# CITY OF ALBUQUERQUE

Hydrology Section Planning Department  
David S. Campbell, Director

June 7, 2019

**RE: BEK Distribution Facility – 601 Gallatin Pl. NW  
G&D Plan and Drainage Report Engineers Stamp Date: 5/16/2019,  
Hydrology File: FJ10D002G1**

LS-101

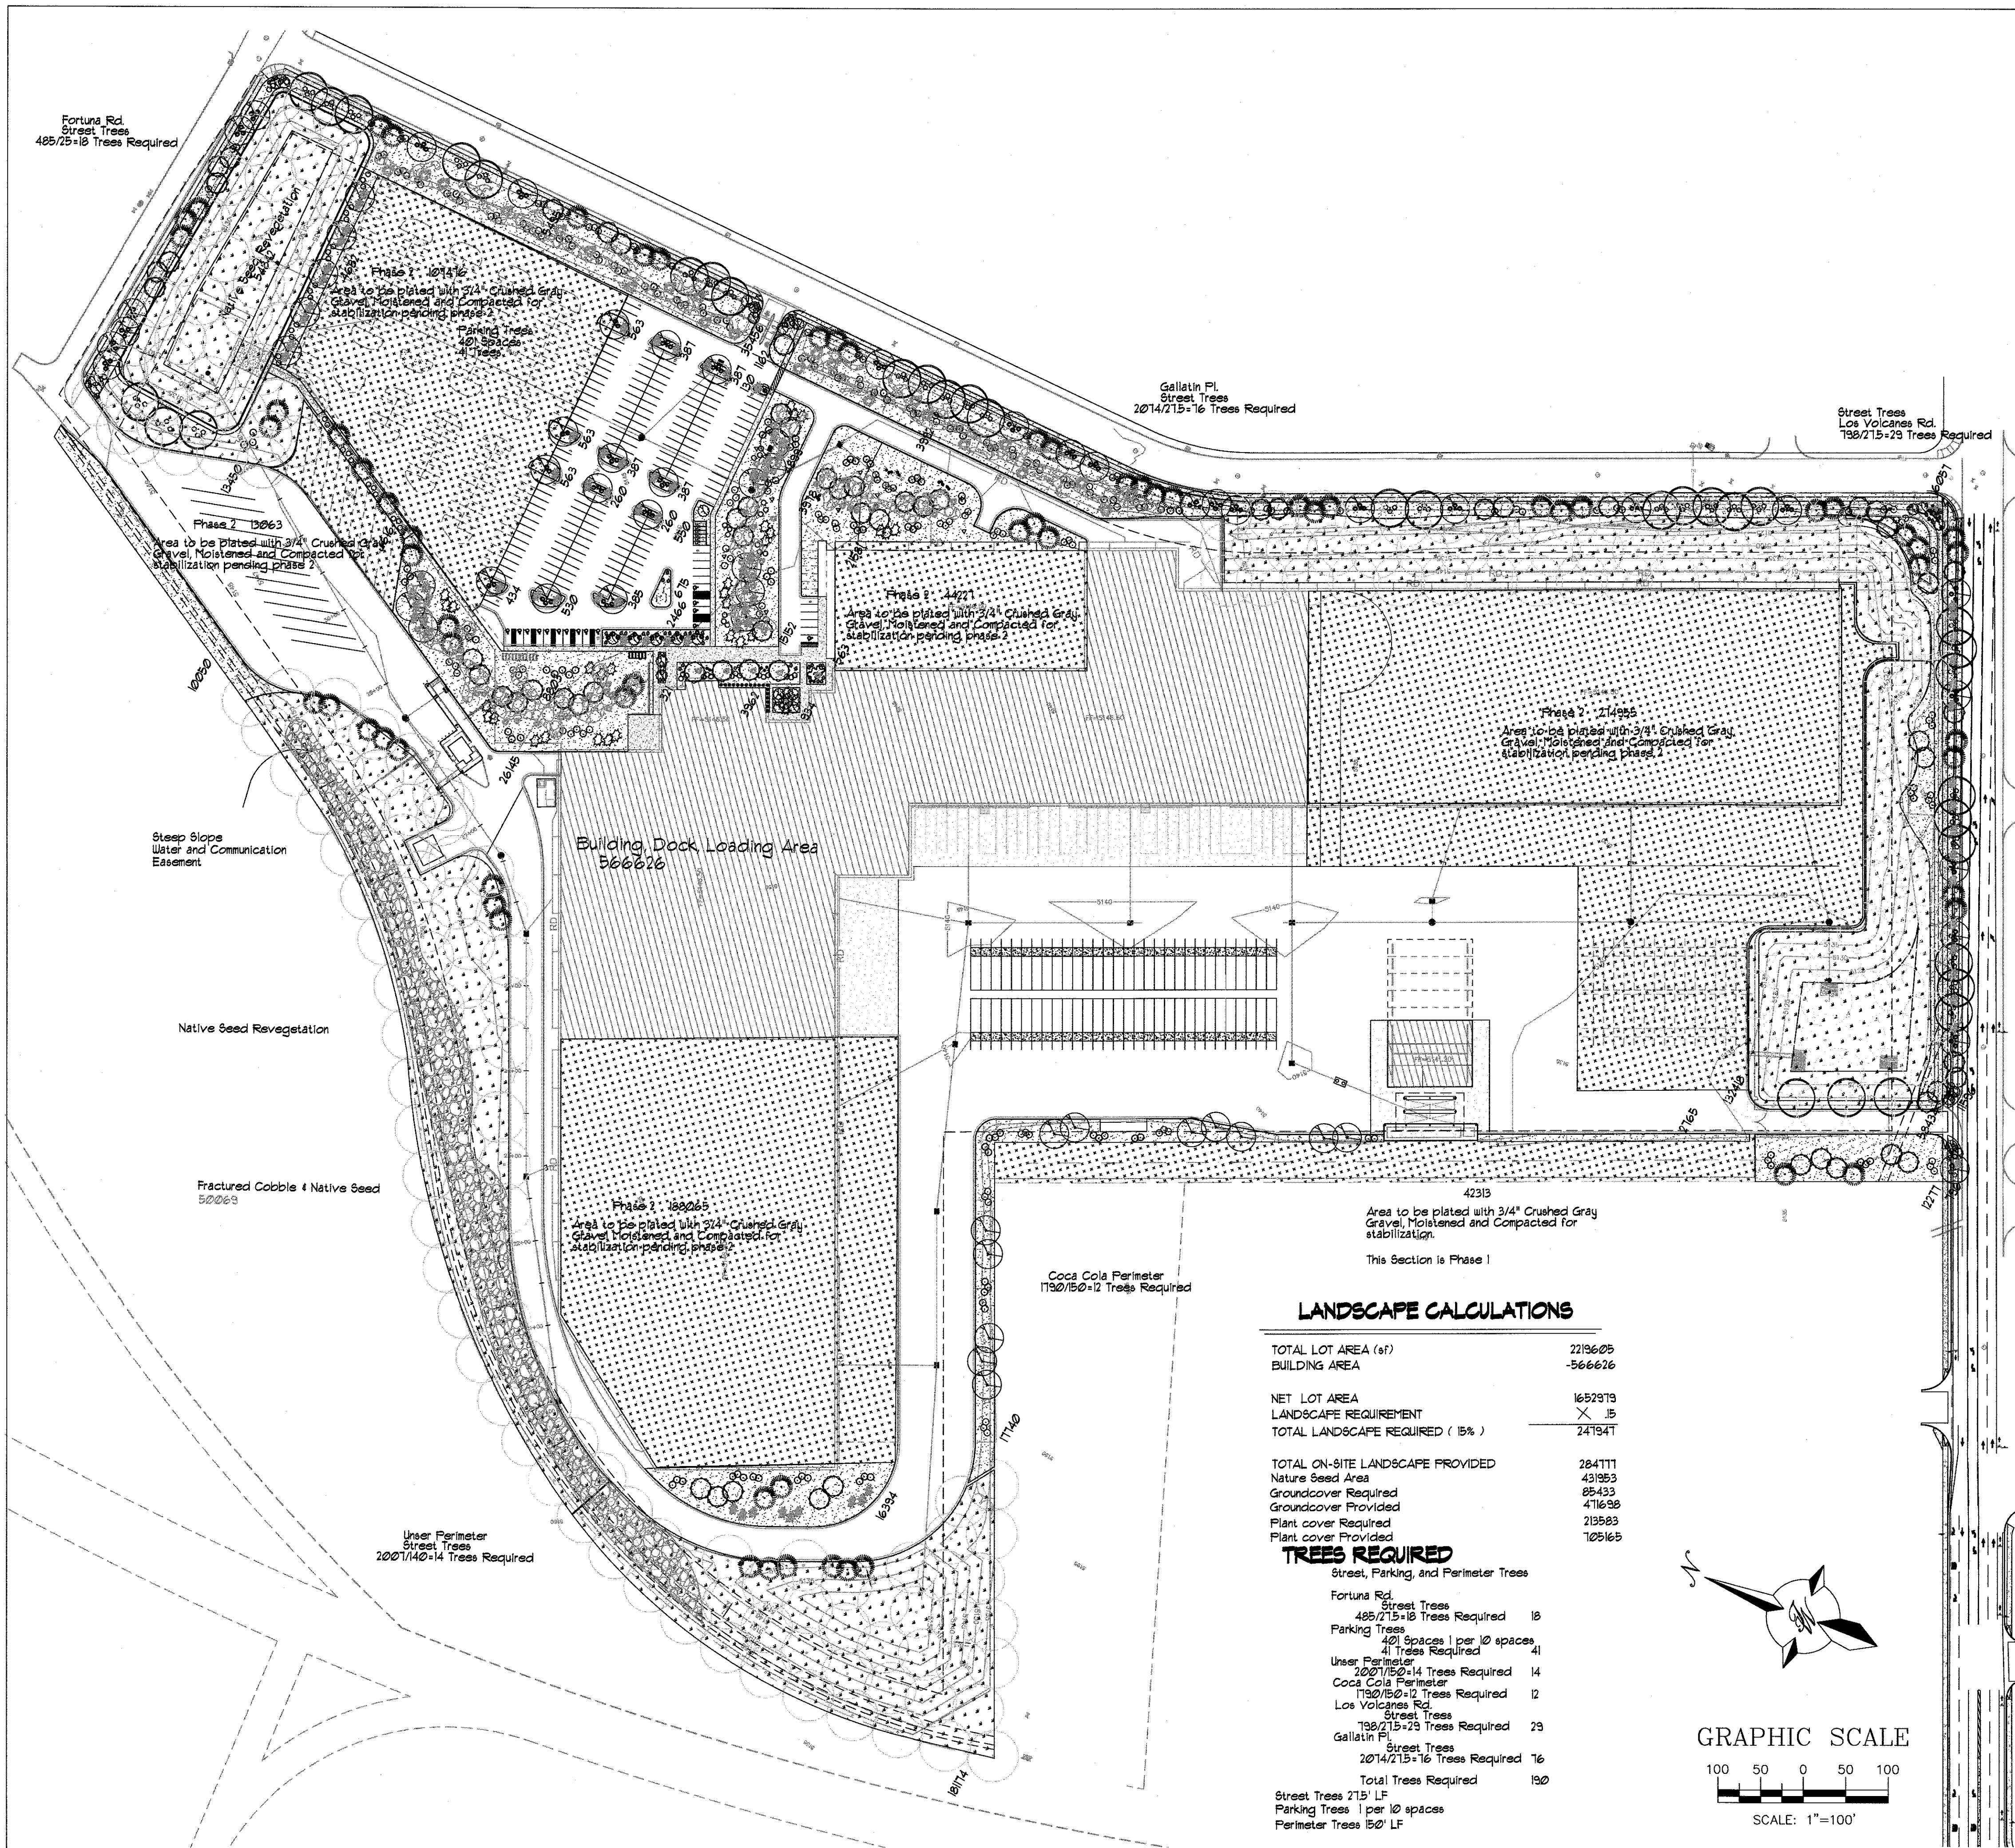
3. The Landscape Plan included in the Site Plan application must be corrected to match the Site Plan and G&D Plan in the west portion of the site as that will be used to identify the steep slope stabilization required in 2 above. Please include a copy of the revised landscape plan when resubmitting the G&D Plan to Hydrology.
